ENG-PUDSP20007-R2-PDRFDR.pdf Markup Summary

See comment letter also

MIDTOWN COLLECTION AT HANNAH RIDGE
FILING NO. 3
DEVELOPED CONDITIONS DRAINAGE MAP

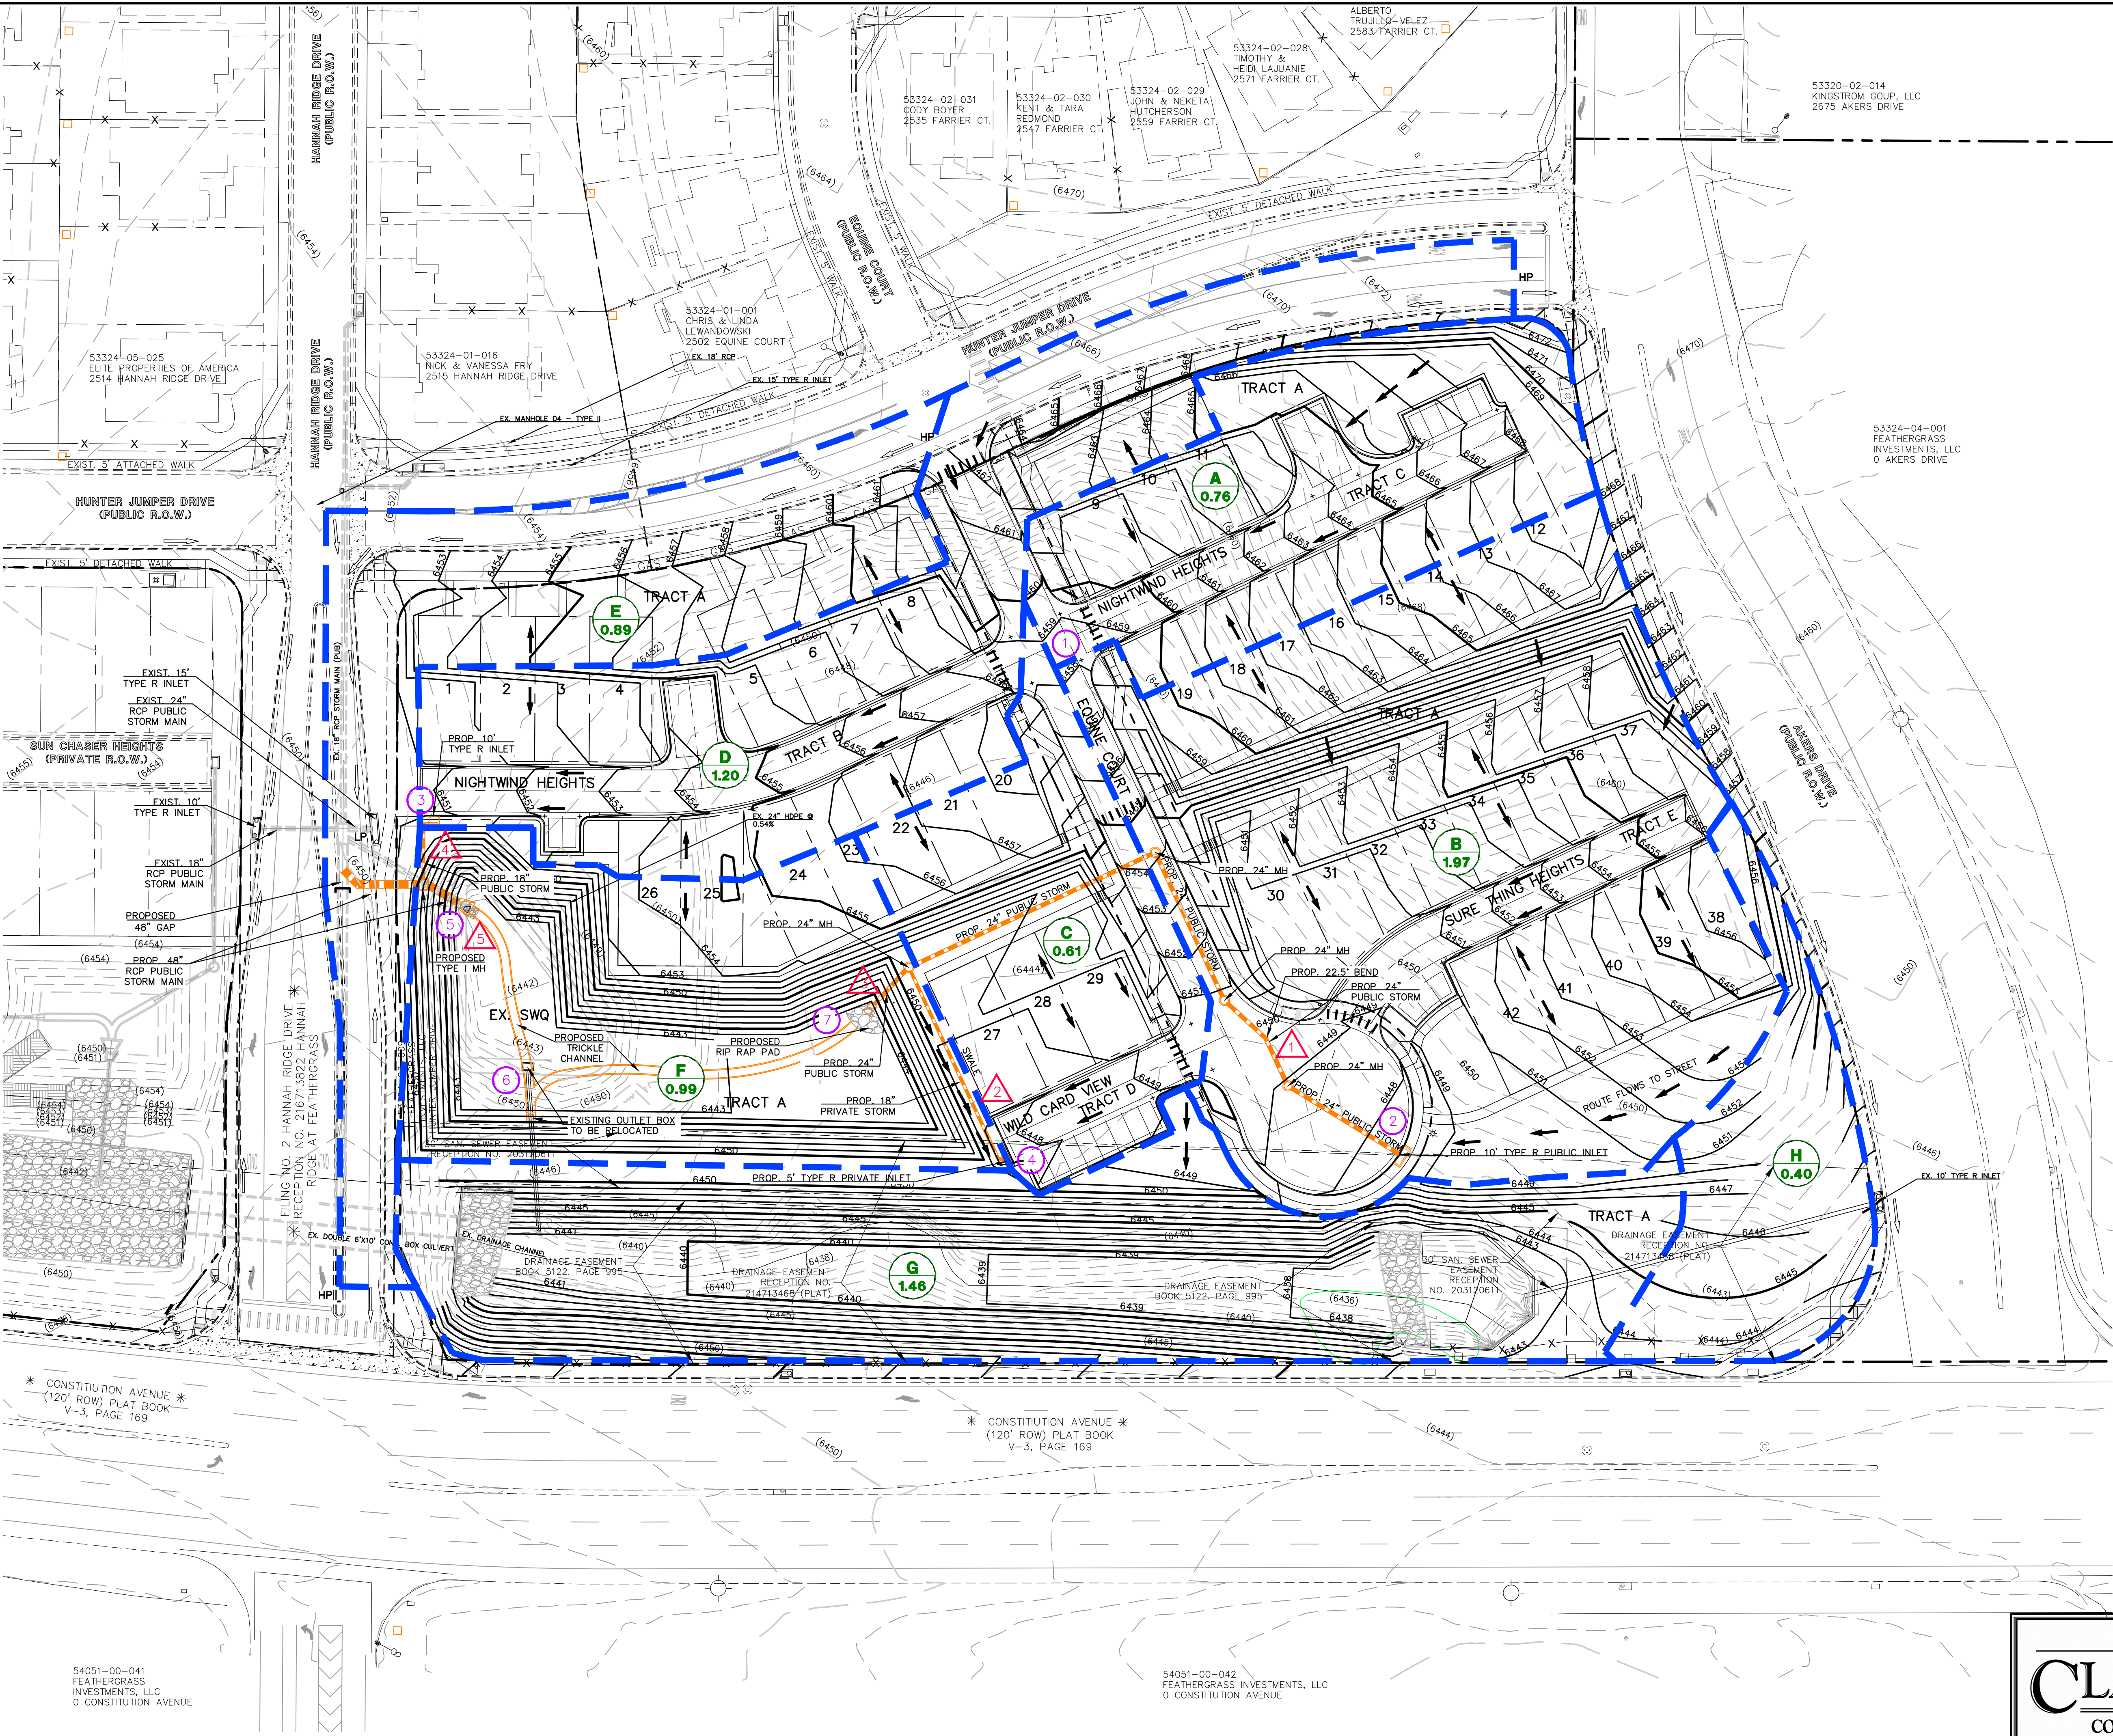
What is GAP?

outlet protection?

Per surface routing spreadsheet, DP 4 is in Basin B-2

Pipe Run 5 shown as 48" pipe in appendix. Update so appendix and map match.

Same design Point Label - Please revise

Clarify flow direction

Pipe material & slope? Include material type & slope on all proposed storm pipes

Label all inlets as private or public

delete note-looks like pipe is no longer here

Design Point 4 per surface routing summary spreadsheet
